CITY OF ALBUQUERQUE

May 27, 2020

**Re: Lot 22 Meridian Business Park
541 Silver Creek Rd NW
Traffic Circulation Layout
Engineer Stamp XX-XX-XX(K10-D023I)**

AUTOTURN EXHIBIT (WB-65)
7-14-2020

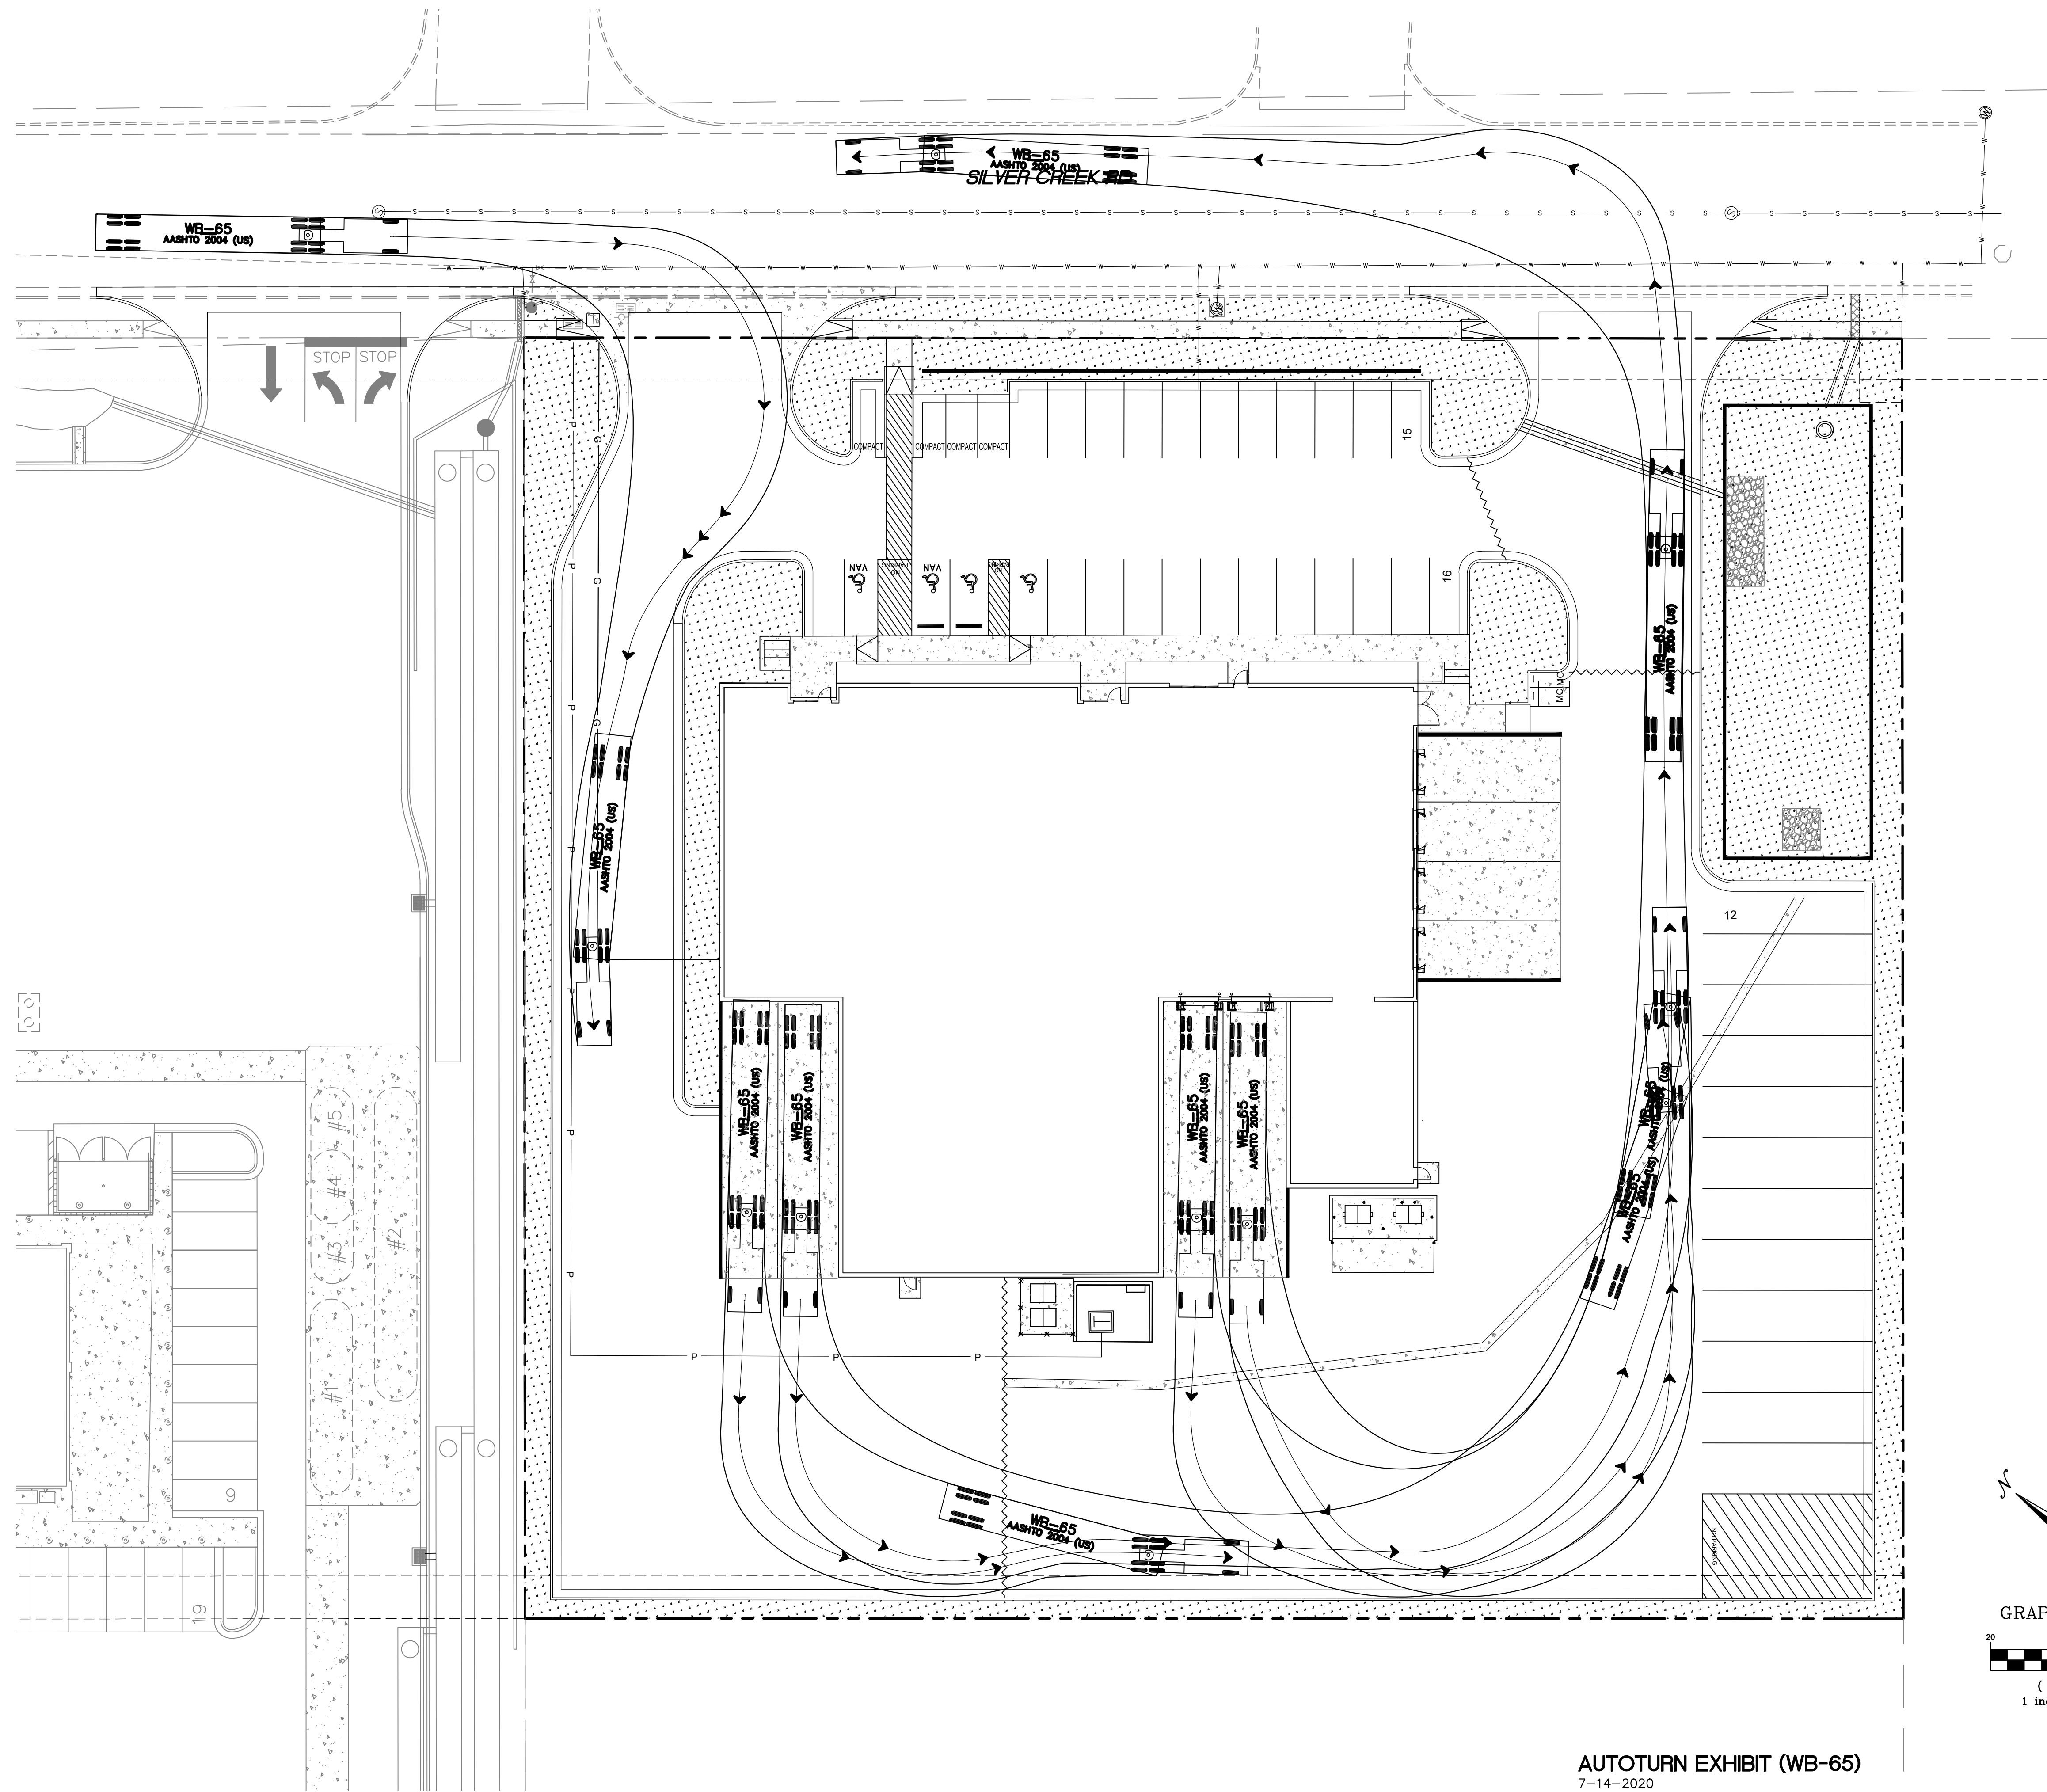
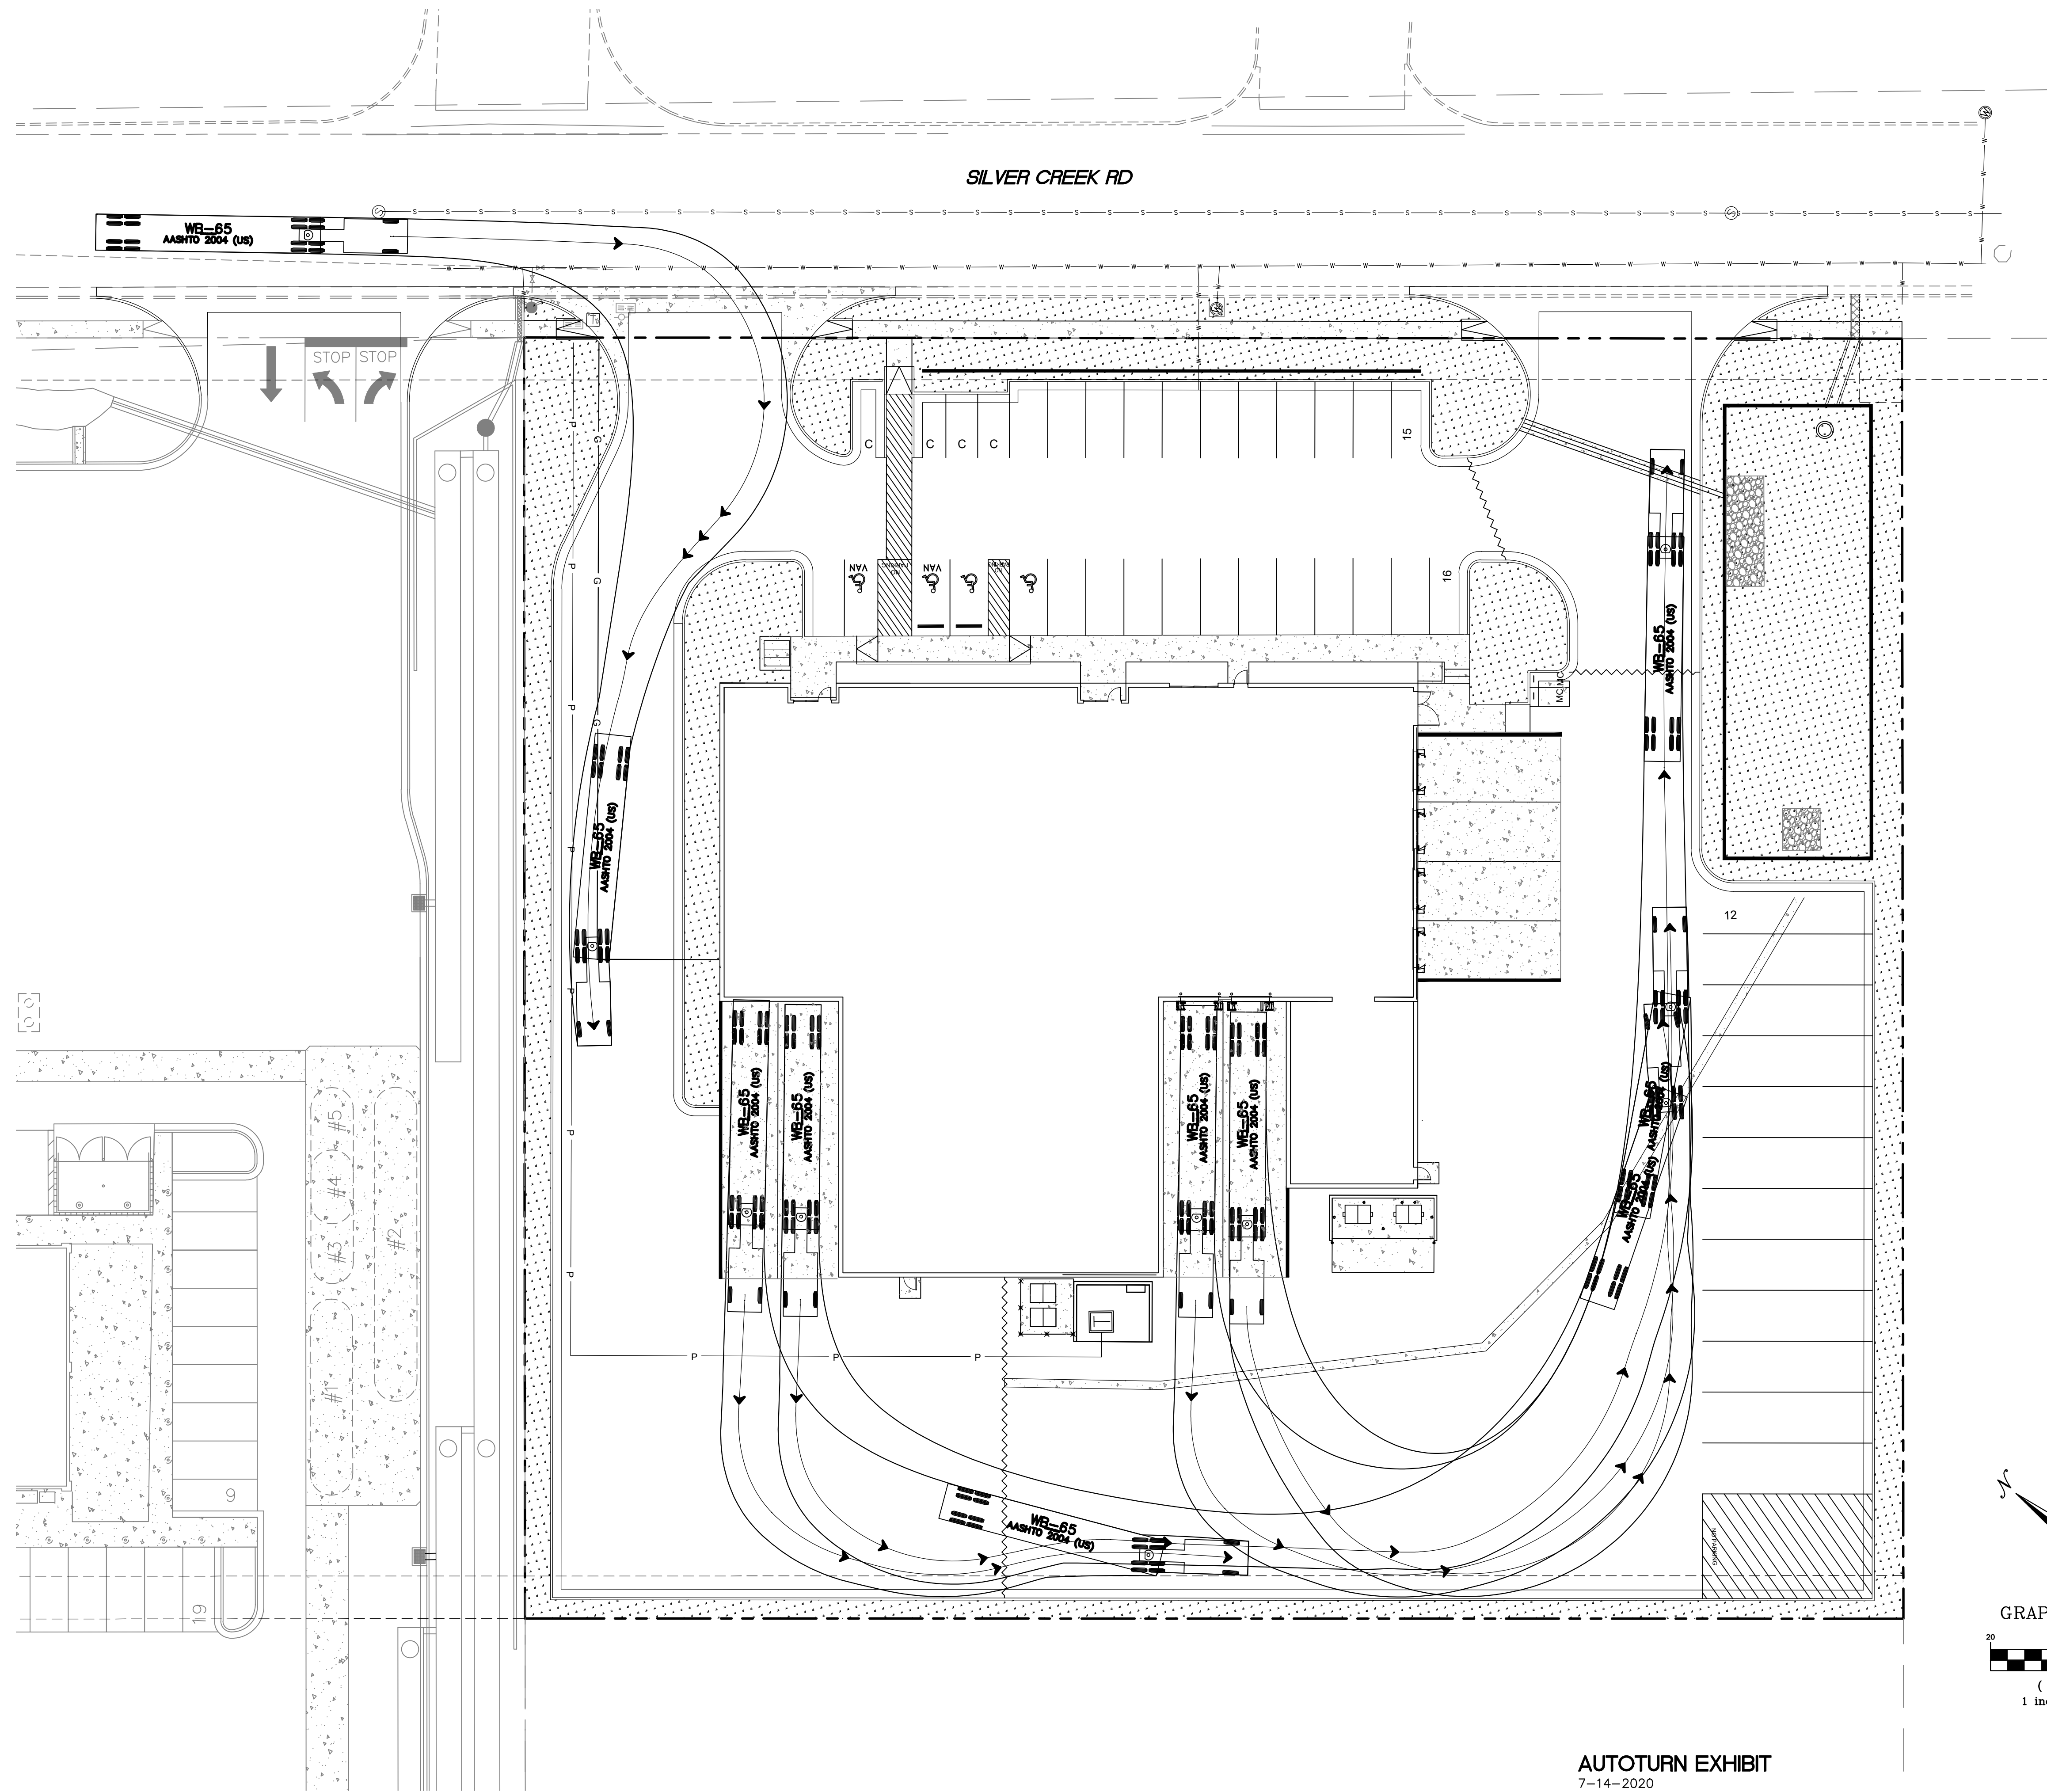
14. Radius for delivery trucks, fire trucks, etc. is 25 ft. or larger. Please provide turning templates for delivery vehicle from public roadway into and out of site.
